**Application, reference 2023/62/92075/W
70 Acre Farm, Meltham Road, Honley HD9 6RG.**

Objection

Project:
Residential Development
at Seventy Acre Farm
Honley
Holmfirth
for Holroyd Homes
CONSTRUCTION PLAN & PROW PLAN 1

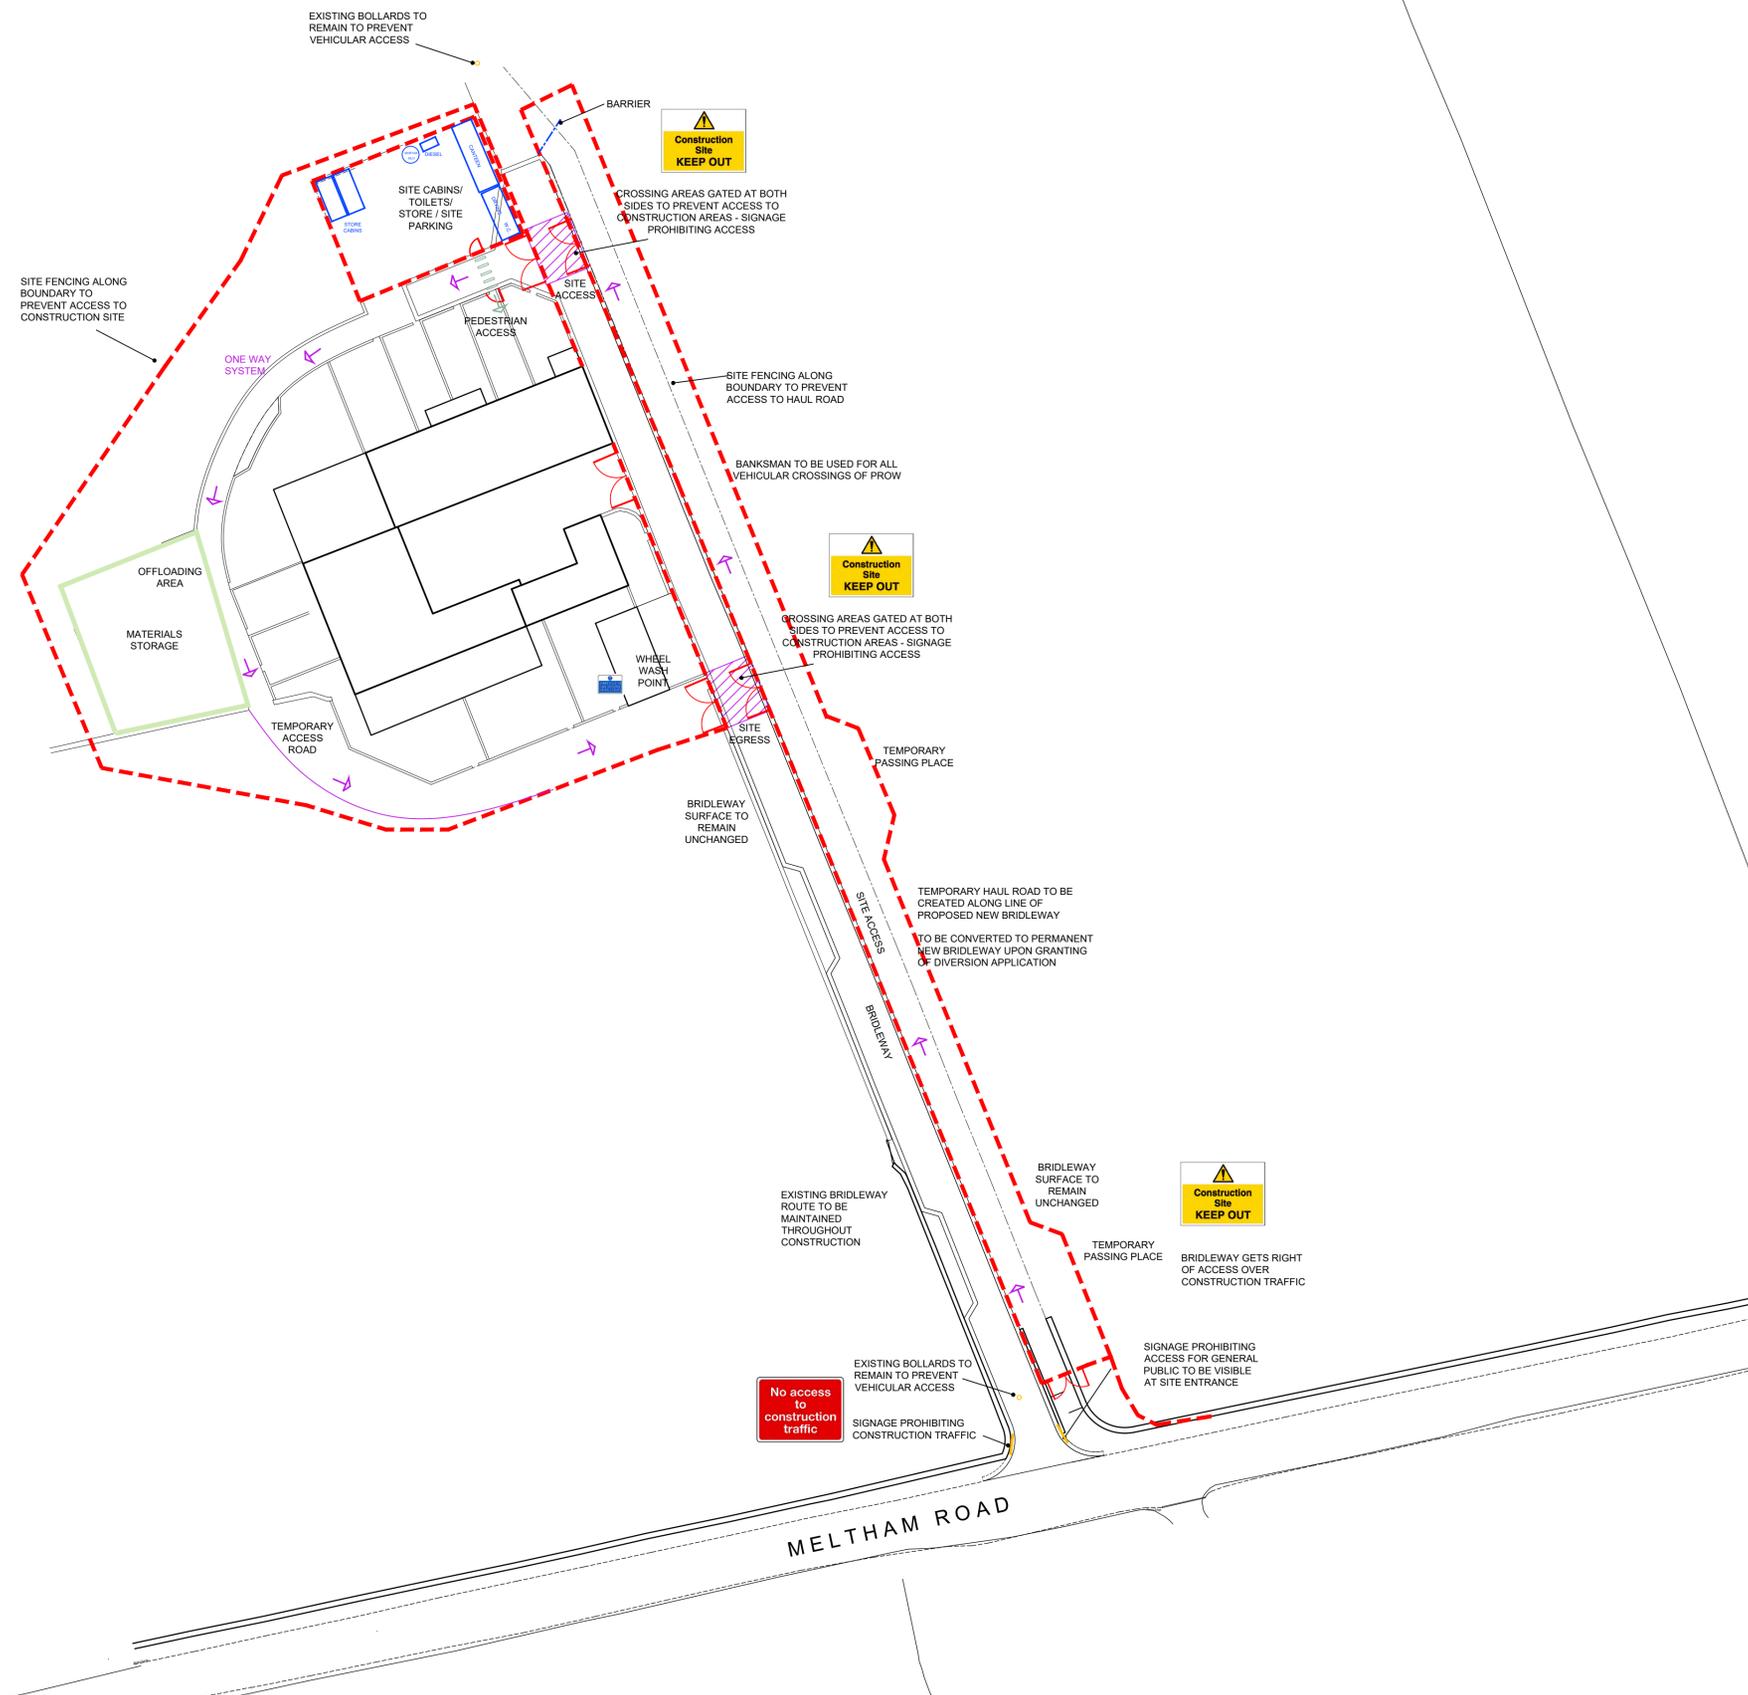
1. We seek clarification on the surface of the bridleway we also note that the application plan 22146-0302 does not show the width of the proposed new bridleway.

2. We would ask that the bin storage area is relocated so that it is not directly adjoining the proposed bridleway posing a potential safety hazard.
3. The Northern end of the bridleway narrows to the point of joining the existing track we ask that dimensions are supplied and added to the plan. It is also not clear if there will be any gradient at this point.

4. There appears to be a new curved entrance joining Meltham Road, we object to this as it requires a horse to manoeuvre around this curved wall whilst traveling downhill and almost doubling back on itself.

5. We note that you have included a staggered barrier entrance joining Meltham Road we would like to see the dimensions of this barrier along with the distance from the entrance.
